**Howerton Services, PLLC**  
**License # P-1716**  
3513 Cathedral Bell Road  
Raleigh, NC 27614  
(919) 270-3460

Subject: Wilkins Residence  
1148 Wade Stephenson Road  
Holly Springs, NC 27520  
Harnett County Permit #: SFD1810-0052  
Plan Revision

BONUS FLOOR PLAN

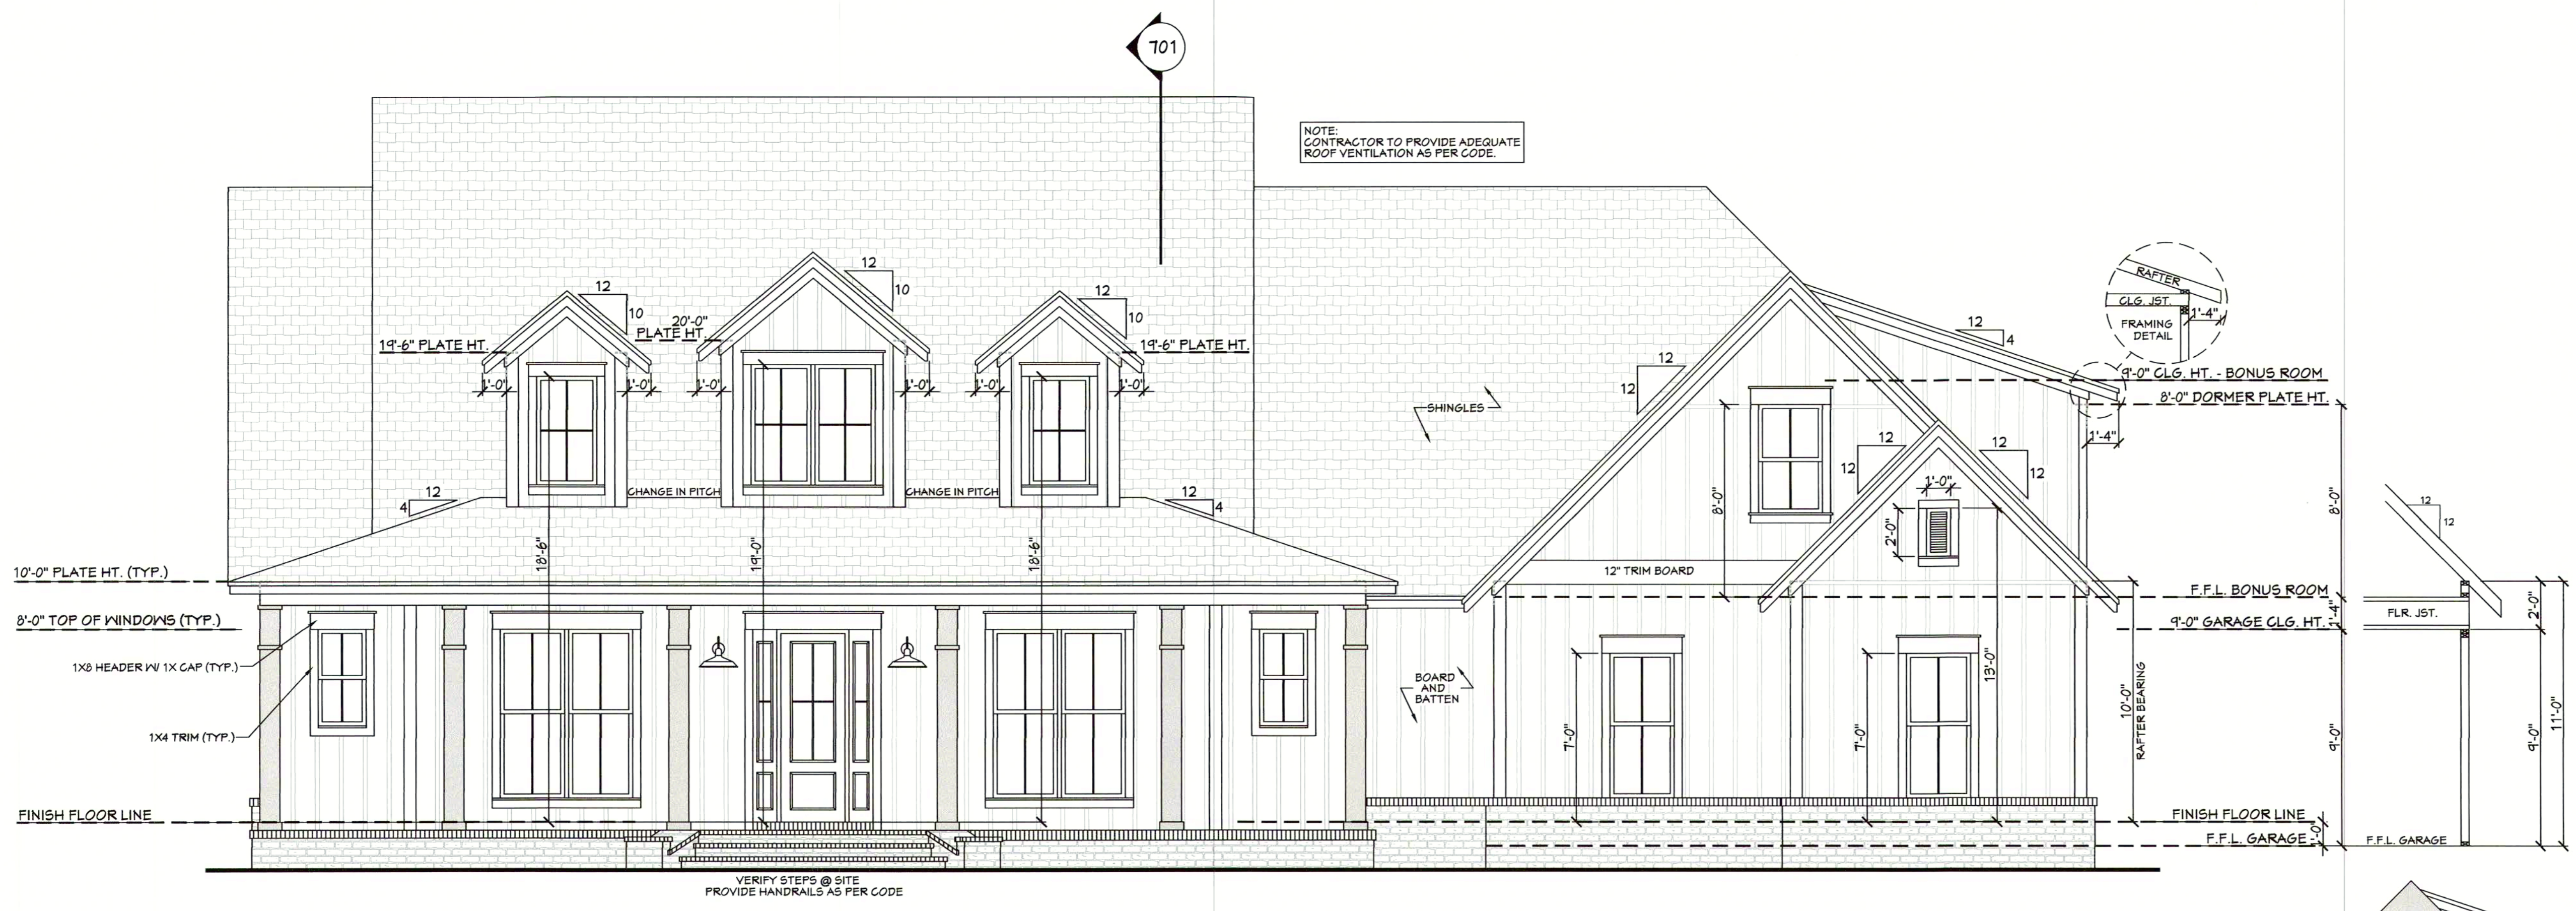
Based on the request of the homeowner, the finished space above the garage was expanded. Additional living space was added over the Master Bedroom. The joists above the Master Bedroom were changed to 2x10s. The dormer over the garage was extended to the space over the Master Bedroom.

The revised items and new framing are acceptable. This revision meets all the requirements of the 2018 North Carolina Building Code for Residences.
